## Rezoning Petition Review

**Rezoning Petition #:** 19-173 (**Revised May 12, 2020**)

**Location of Property:** Approximately 150 acres located off Garrison Rd, west of I-485 and south of West Blvd.

ENGINEER: GTW
 DRAWN BY: EBT
 CHECKED BY: LJB
 PROJECT #: 019.039
 SHEET: **RZ-1**
 SHEET 1 OF 5

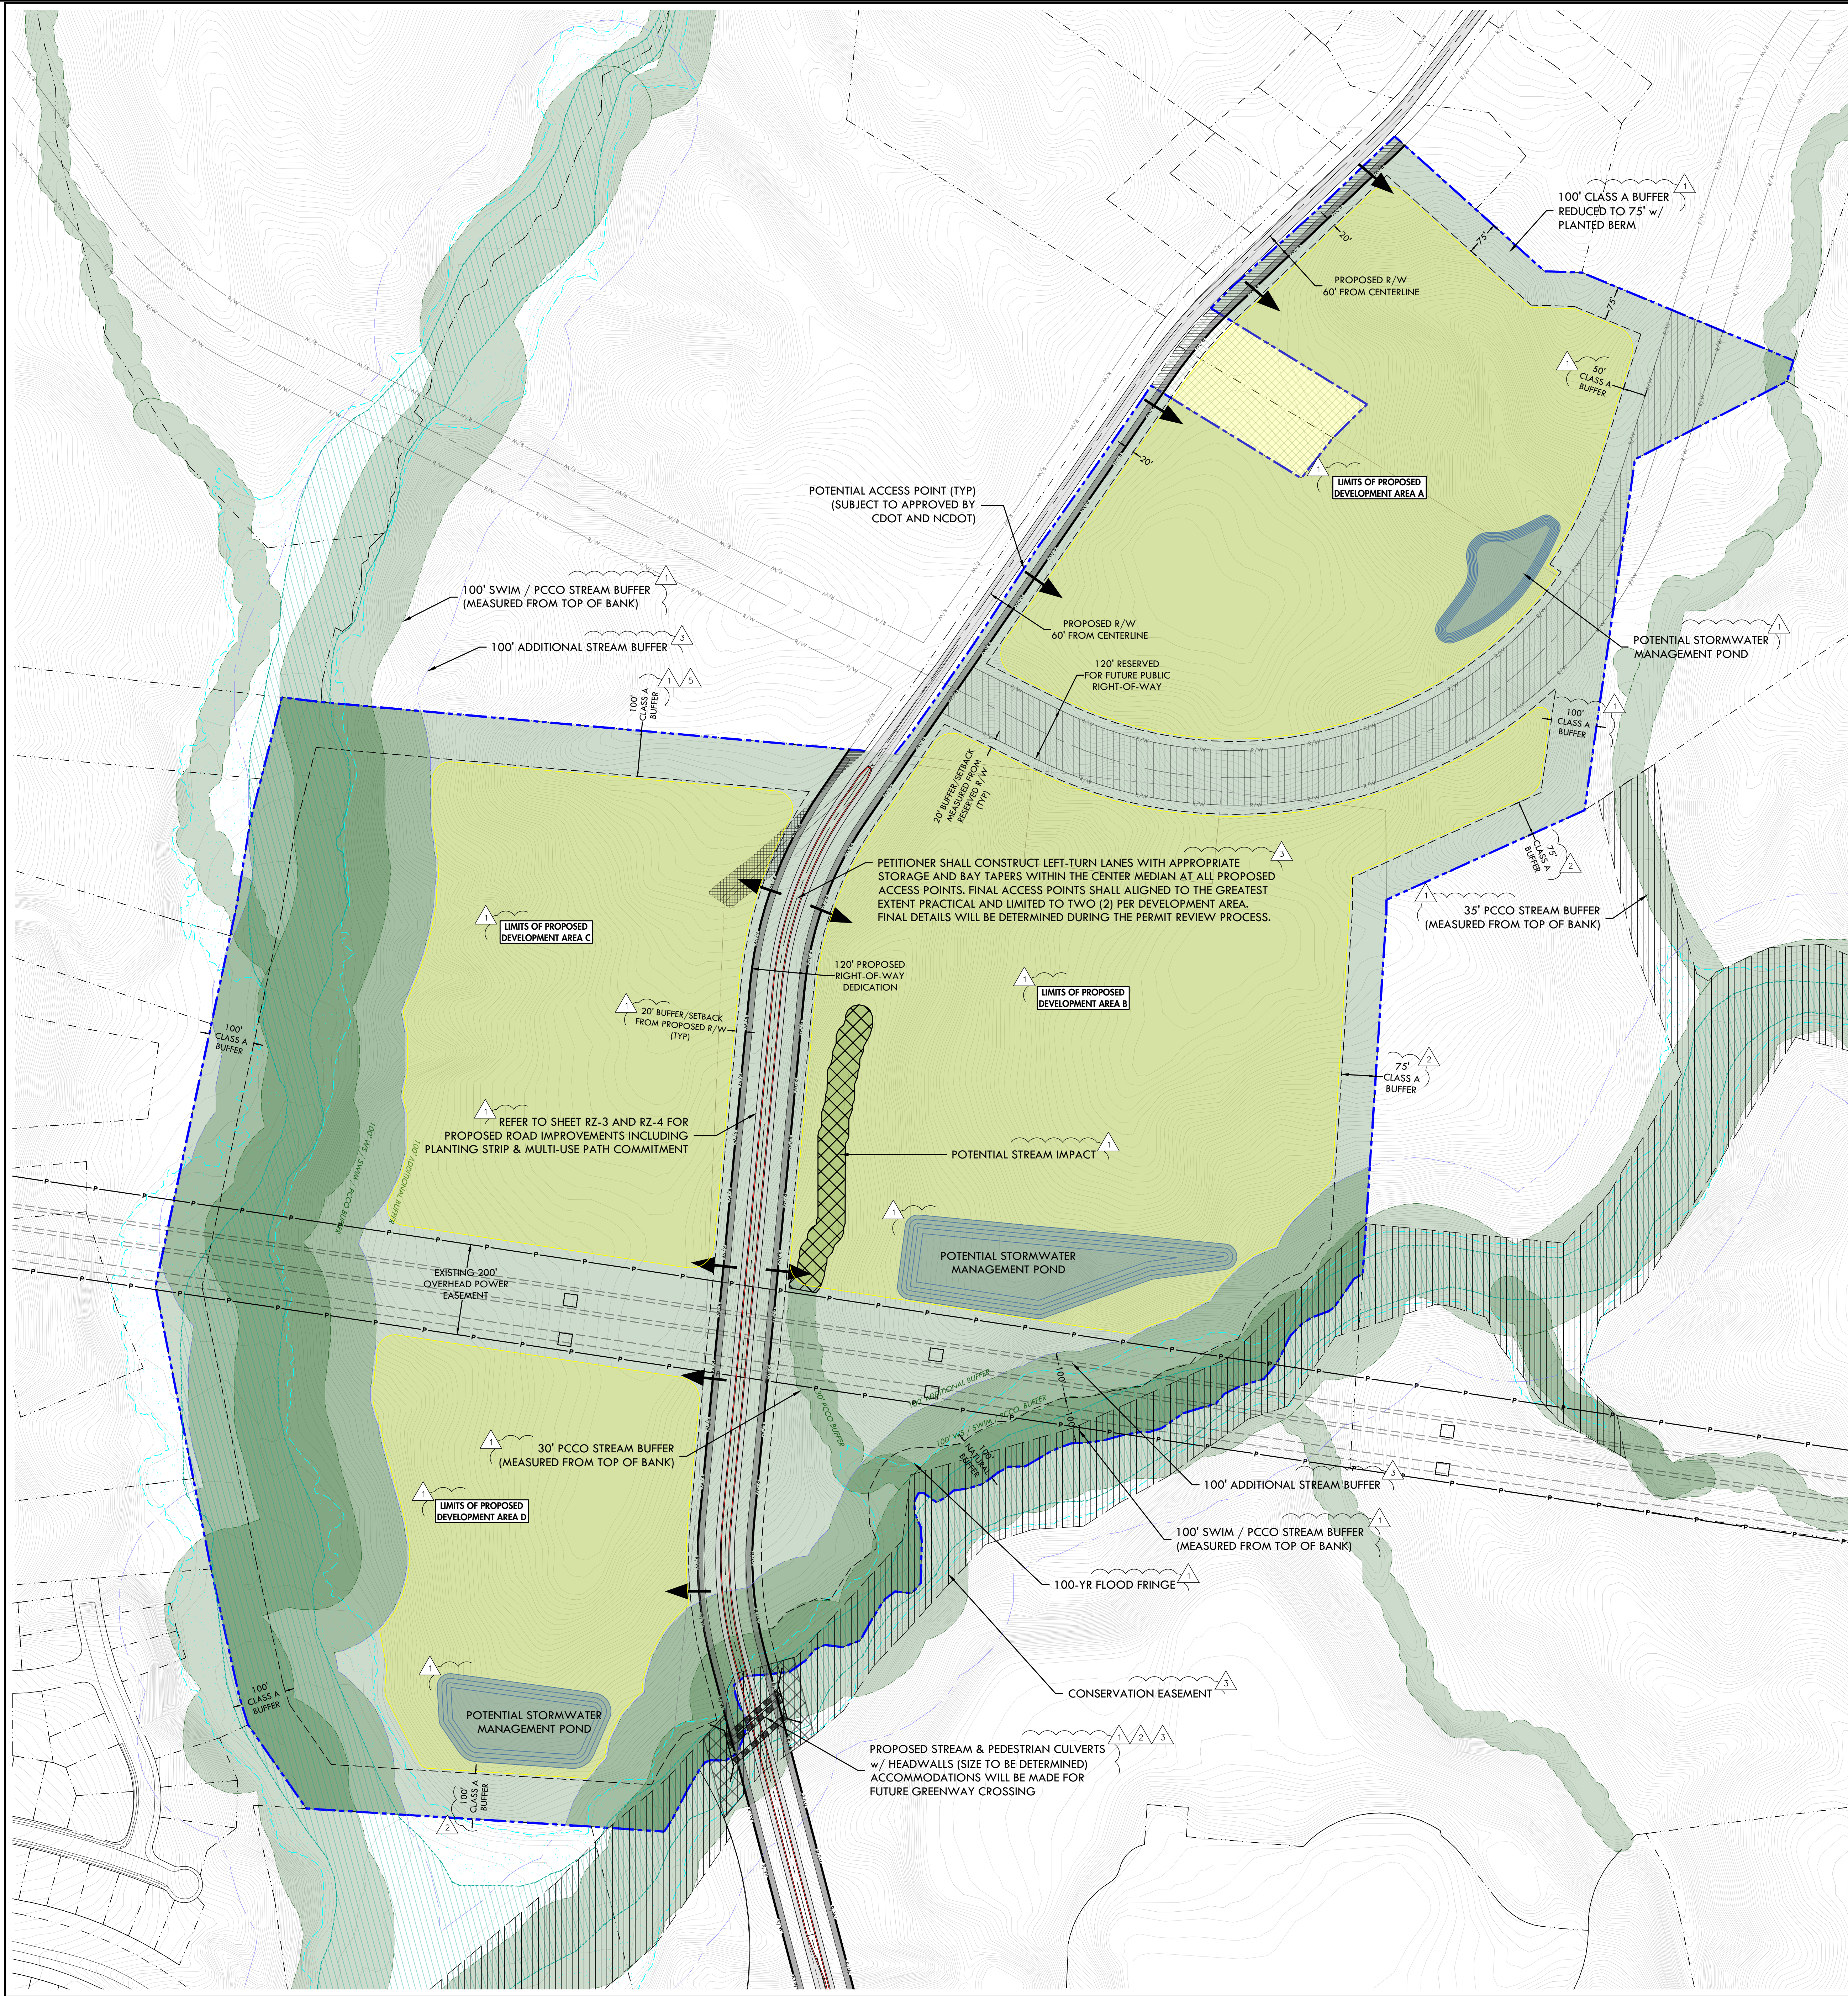
**Concerning Storm Water:** Please show and label SWIM and/or PCSO buffers on the site plans. Any increase of impervious area within such buffers may not be allowed and is not approved with the rezoning process. Please include the following note under "Environmental Features": *"Development within any SWIM/PCSO Buffer shall be coordinated with and subject to approval by Charlotte-Mecklenburg Storm Water Services and mitigated if required by City ordinance. Petitioner acknowledges intermittent/perennial stream delineation reports are subject to review and approval upon submission of development plans for permitting and are not approved with rezoning decisions."*

ENGINEER: GTW
DRAWN BY: EBT
CHECKED BY: LB
PROJECT #: 019.039
SHEET
RZ-2
SHEET 2 OF 5

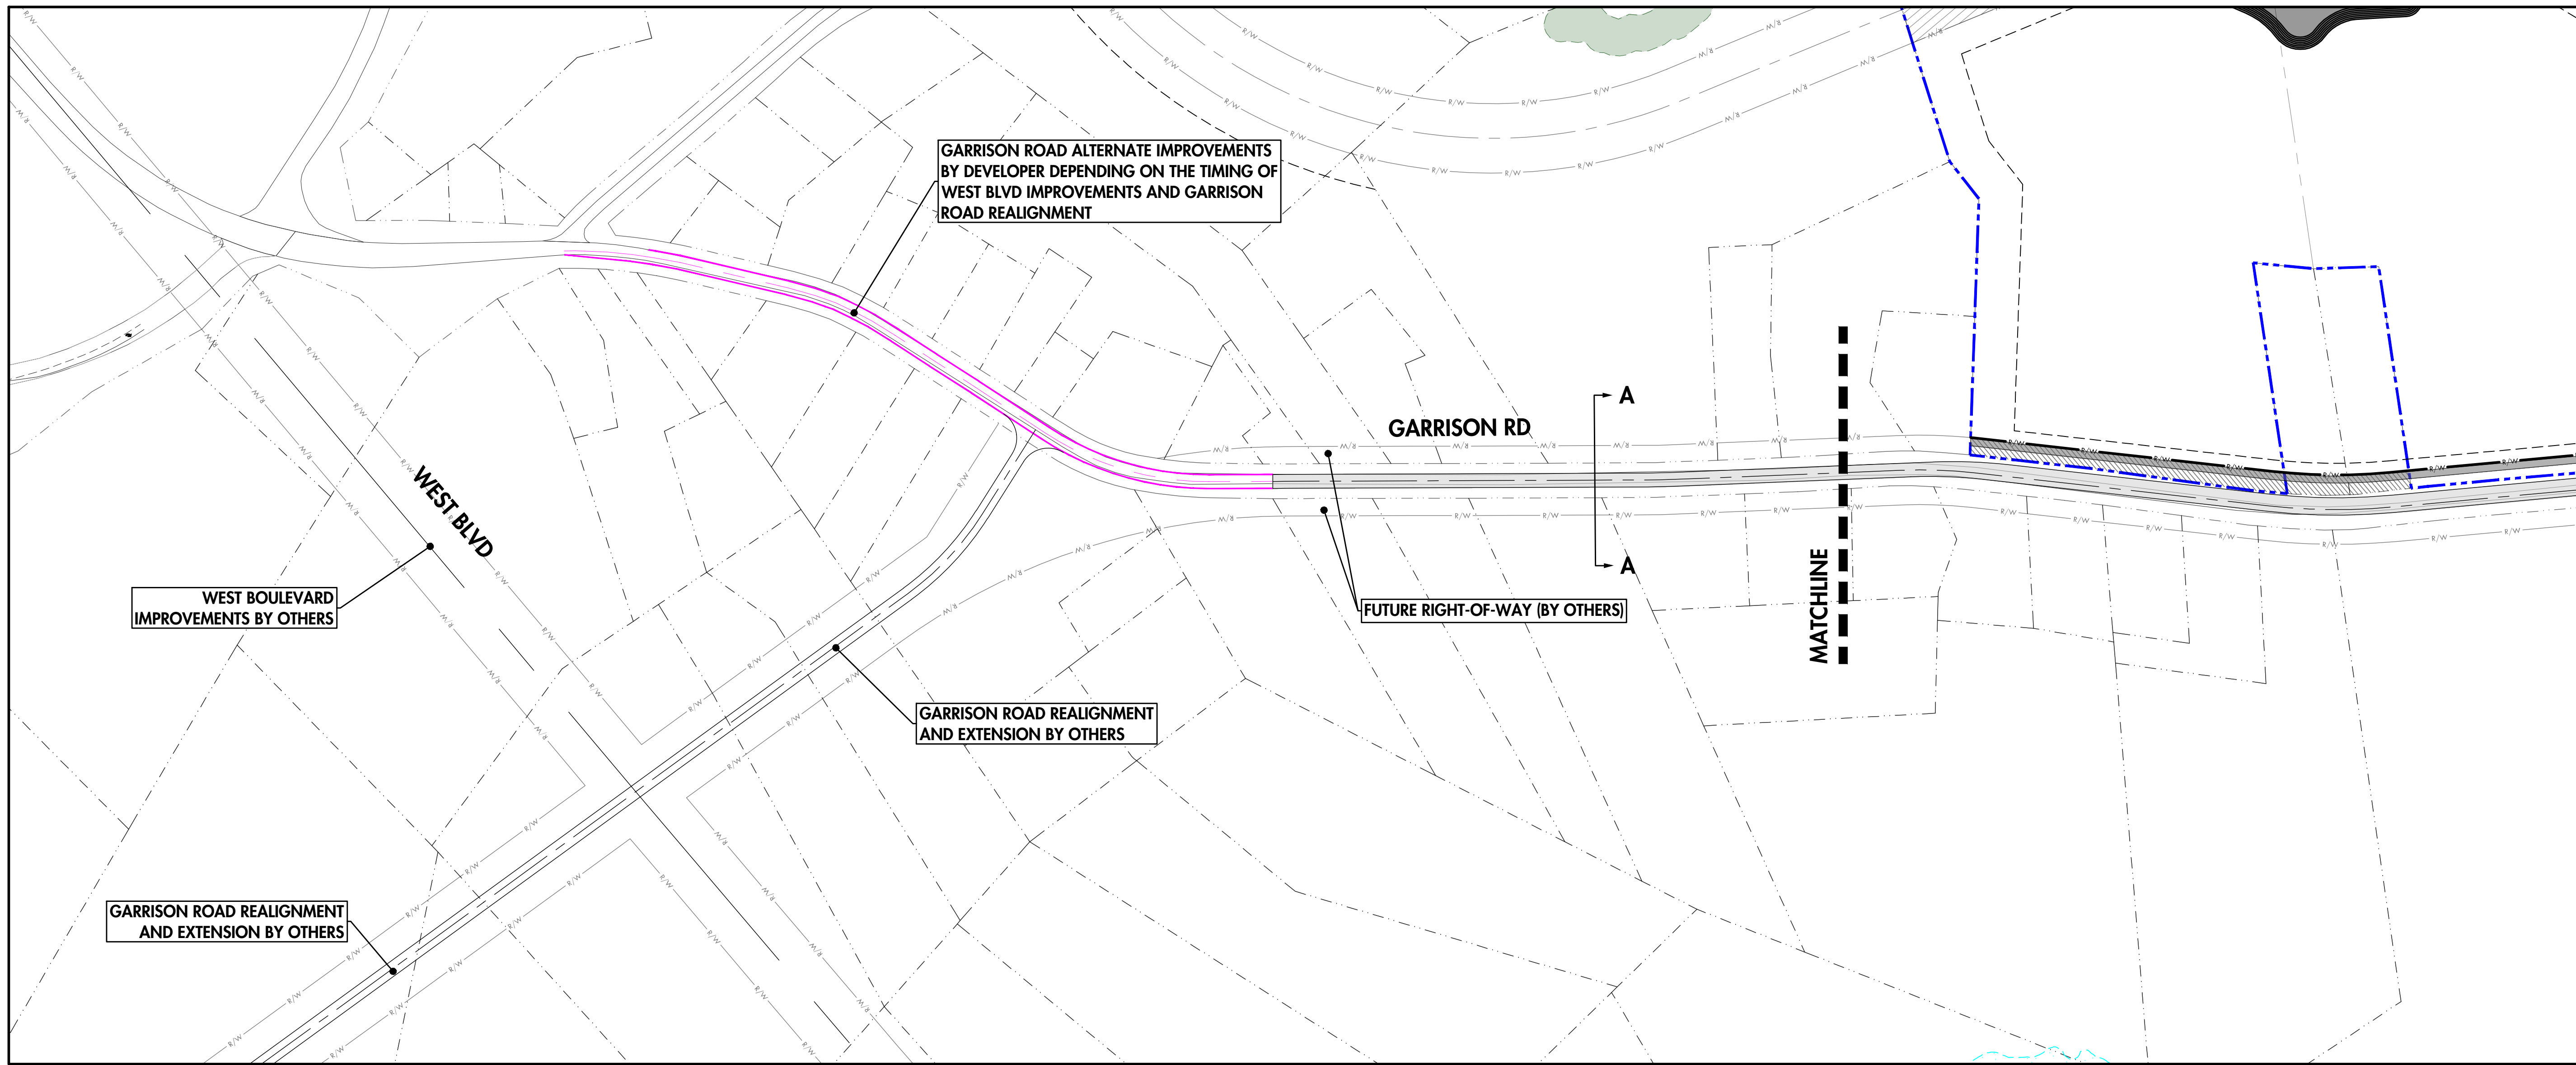
The proposed rezoning plan sheet indicates a proposed location for storm water management. Please include the following notes on the plan sheet under "Environmental Features": *The location, size, and type of storm water management systems depicted on the Rezoning Plan are subject to review and approval as part of the full development plan submittal and are not implicitly approved with this rezoning. Adjustments may be necessary in order to accommodate actual storm water treatment requirements and natural site discharge points.*
